Appeal Decision

Appeal Ref: 6004586

22 Park Road, Hayes, Hillingdon UB4 8JN

- The application sought planning permission for *demolition of existing dwelling and garage, erection of a 4-bedroom 8 x persons dwelling* without complying with conditions attached to planning permission Ref 78540/APP/2024/229, dated 17 May 2024.

PROPOSED LOFT PLAN
1:50

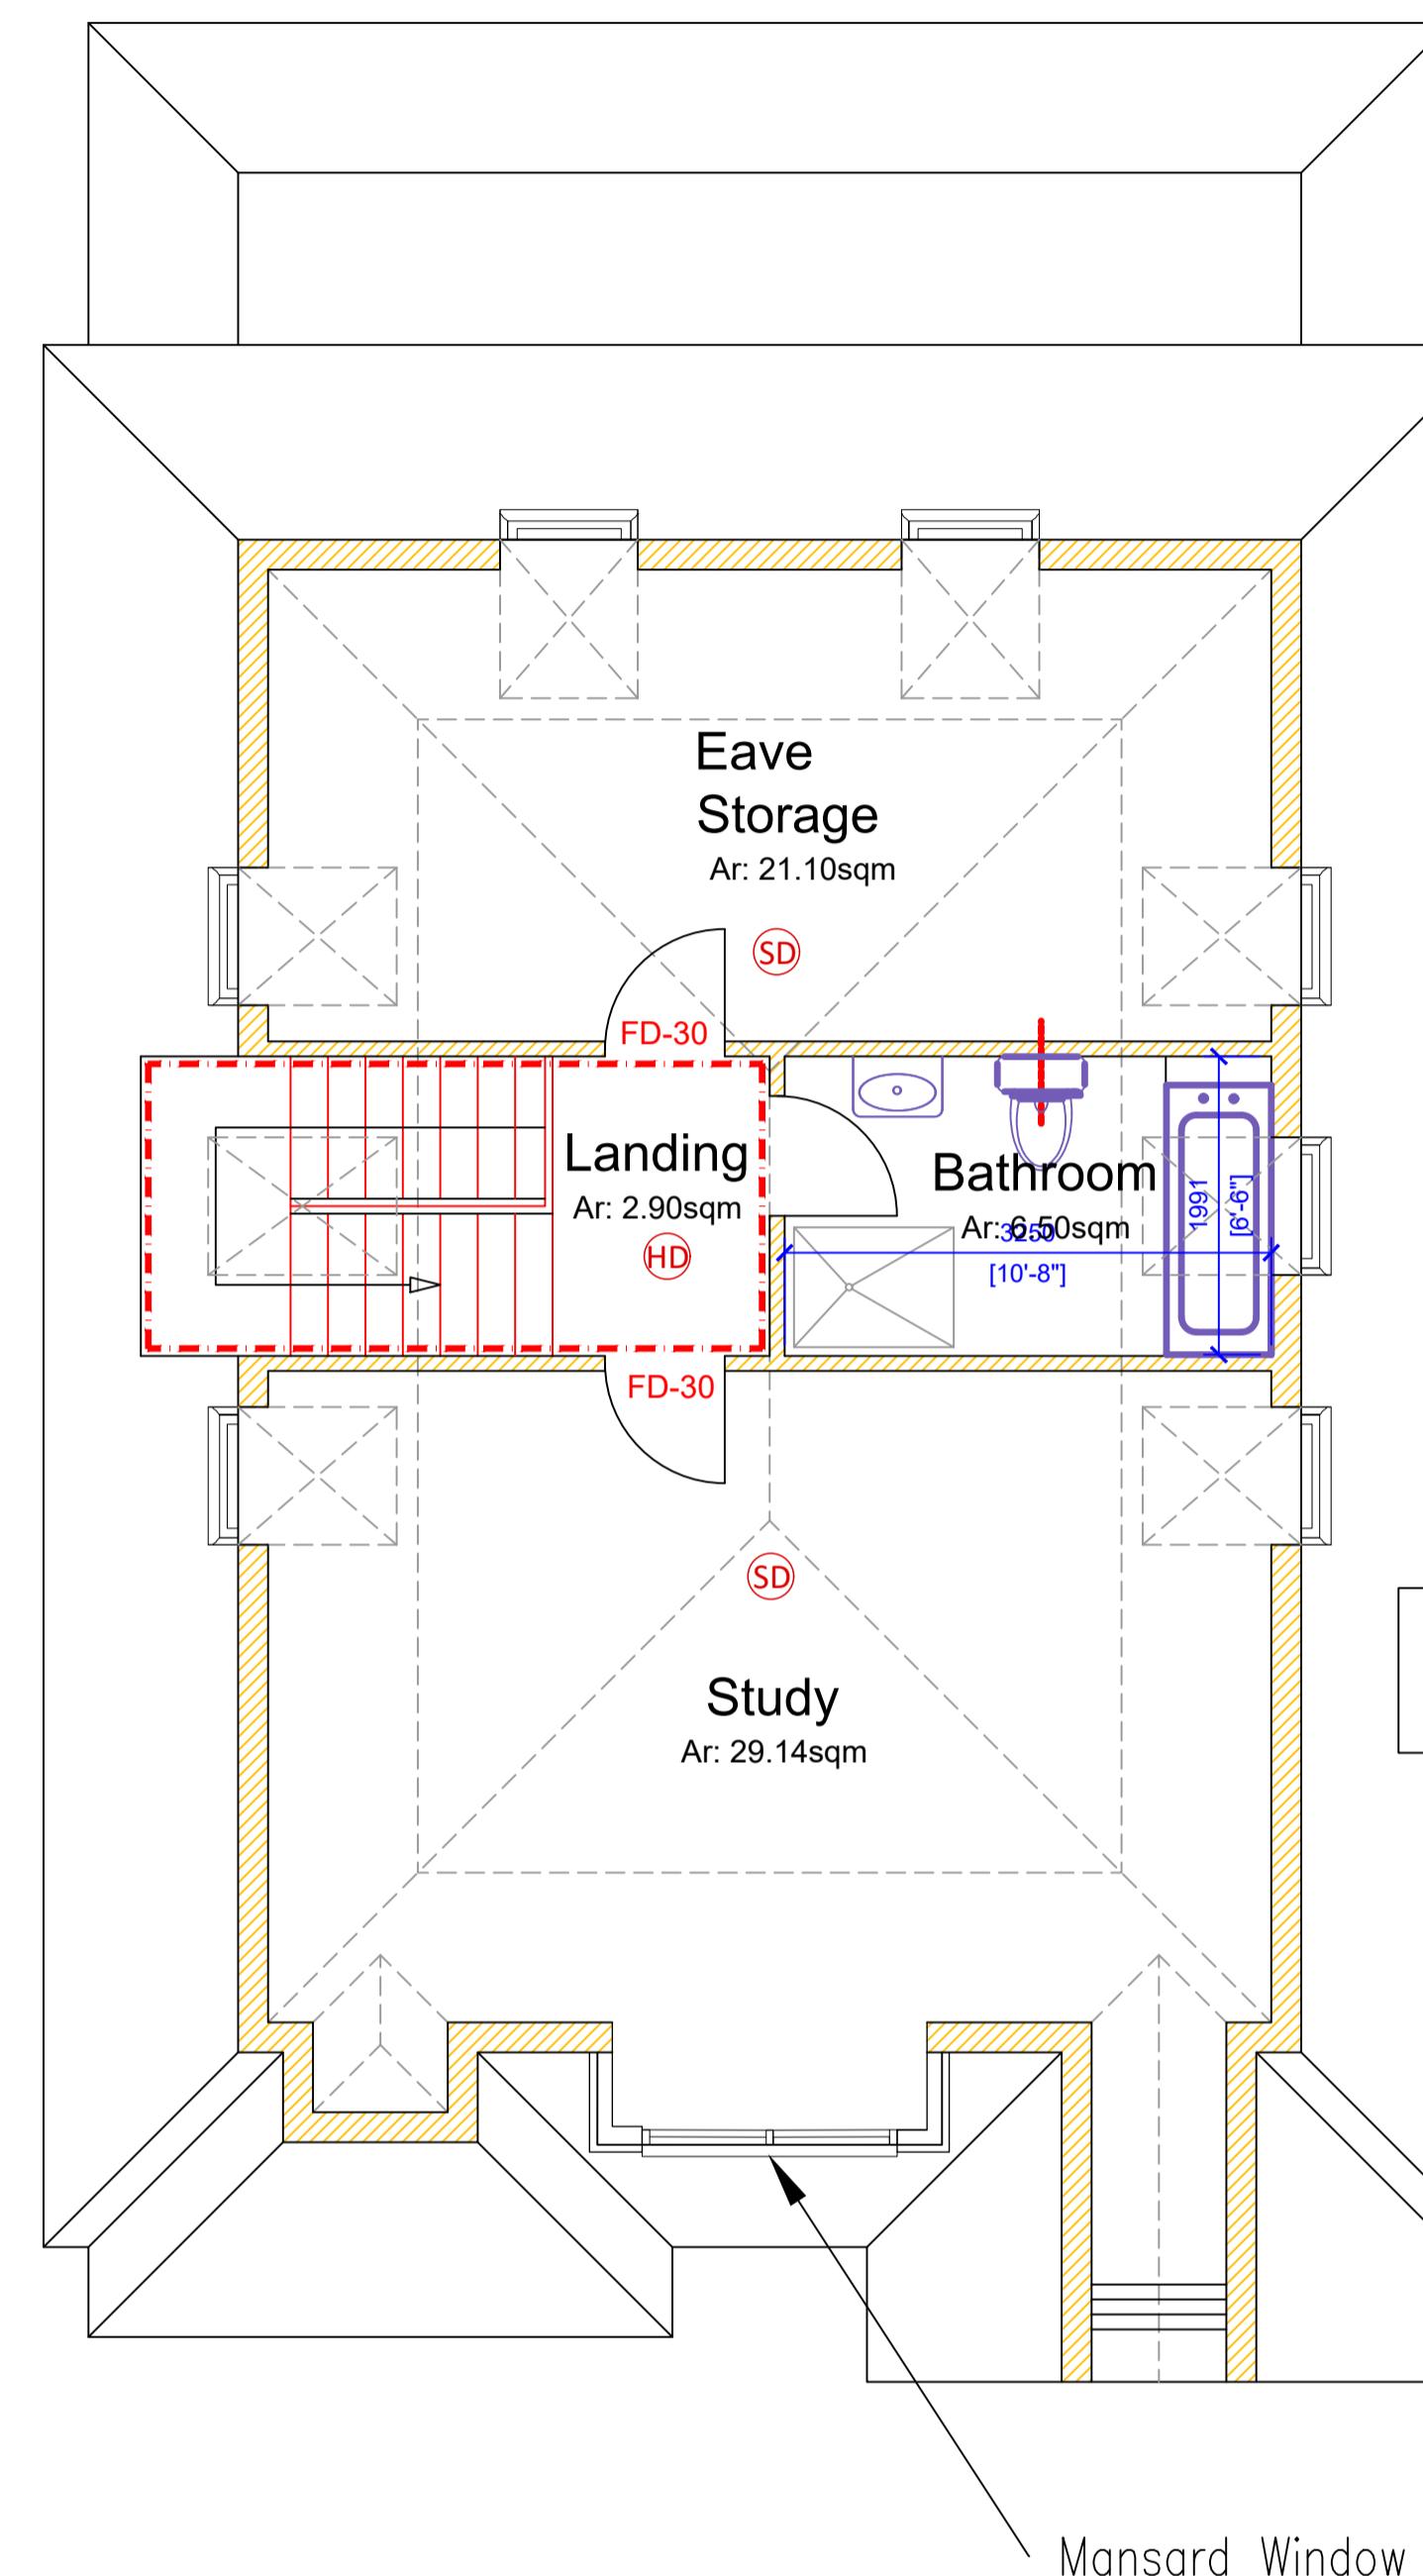
8. A curved eyebrow style dormer has been constructed on the front roofslope of the appeal property. The dormer is of a relatively small scale and sited centrally on the roofslope between the projecting hipped canted bays. The scale of the dormer allows clear spacing to be retained to the roof slopes, ridge line and eaves. Nevertheless, even though the alignment of the dormer corresponds with that of the windows at first floor level, it appears as a discordant and unduly prominent feature. This is primarily as a result of its design and form which contrasts starkly with and relates poorly to the modern, angular design of the host property. Consequently, notwithstanding that the property is neither listed nor located within a Conservation Area, the dormer detracts from its overall appearance and architectural composition.

9. While mature trees lining Park Road screen the dormer to an extent, it is visible in some views from Uxbridge Road. It is also visible from Park Road. In these views, the dormer appears incongruous by reason of its design at odds with that of the appeal property.

10. I acknowledge that the absence of front dormers in the surrounding area does not necessarily mean that such development would be at odds with the character and appearance of the area. Nonetheless, in this case, for the reasons set out above, the design fails to harmonise with the host property, consequently appearing as a discordant feature in the street scene.

11. Accordingly, I conclude that the front dormer window has a harmful effect on the character and appearance of the host dwelling and surrounding area. As such, it is contrary to the relevant provisions of Policy BE1 of the Hillingdon Local Plan: Part One – Strategic Policies (2012), Policies DMHB 11, DMHB 12 and DMHD 1 of the Hillingdon Local Plan Part 2 – Development Management Policies (2020) and Policy D3 of the London Plan 2021. Among other things, these policies seek development which harmonises with and enhances local context, makes a positive contribution to and integrates with the surrounding area and has no adverse cumulative impact on the character, appearance or quality of the existing street or wider area.
